Our Case Number: ABP-318802-24

Re: Proposed development of a resource recovery centre (including waste-to-energy facility)
in Ringaskiddy, County Cork.

Observation on SID application – case reference PA04.318802, Ringaskiddy, Co Cork.
Proposed development of a waste incinerator by Indaver NV, t/a Indaver Ireland.

Submitted by Dr Gordon Reid, Bracken, Boardee, Carrigaline, Co. Cork
17th November, 2025

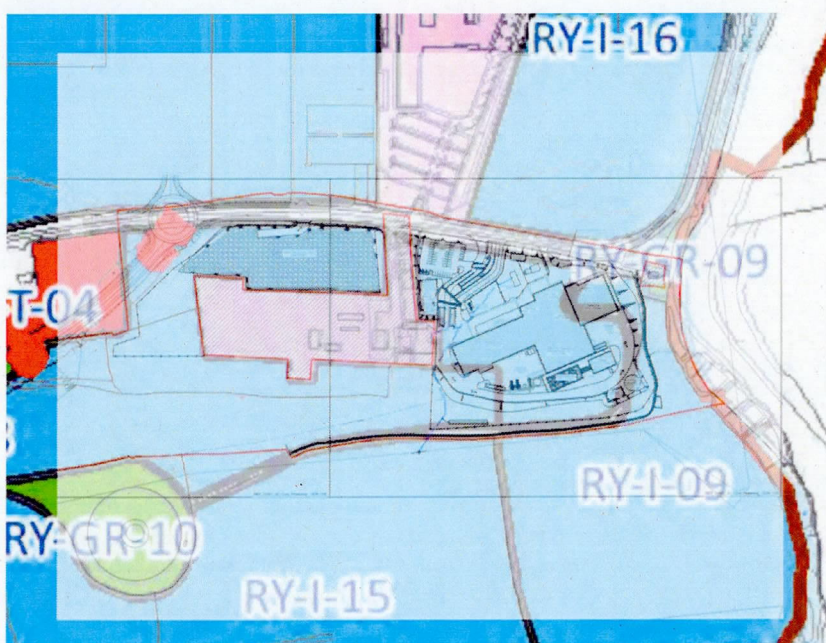
The site for the proposed incinerator is thus presented as 'predominantly' industrial, and 'part' educational. *This presentation has the potential to seriously mislead any reader. In truth, the piece of land on which the proposed incinerator would be built is not predominantly zoned as industrial: it is almost entirely in the part zoned for educational use.*

The left and right panels above are unaltered and drawn from the County Development Plan and the current planning application respectively. The centre panel is an accurately scaled superimposition (by reference to land features such as the Hammond Lane Metals site, the road, and the Martello Tower) of the left and right panel. It is clear that, apart from a very small corner of the building, the incinerator site is entirely contained within the education zone, RY-I-09.

It will be noted from the left panel that the map presented in the County Development Plan has labels on each of the zones, so it is obvious which part of the land is RY-I-09 and which is RY-I-15. In contrast, the map presented by Indaver completely lacks labels, so that it is impossible to understand from their map which part of the land is in which zone. One must go to the County Development Plan, as I had to do, to find that out.

I think it is reasonable to expect an applicant to give fair and accurate information to An Coimisiun Pleanála, and that in a section on zoning, the information and map should actually clarify the zoning. But in this case, the map fails to show which zone is which, and *the information given in the application actually gives an impression that is the opposite of the truth. The site of the proposed incinerator is not 'predominantly zoned RY-I-15', it is almost entirely in the educational zone RY-I-09.*
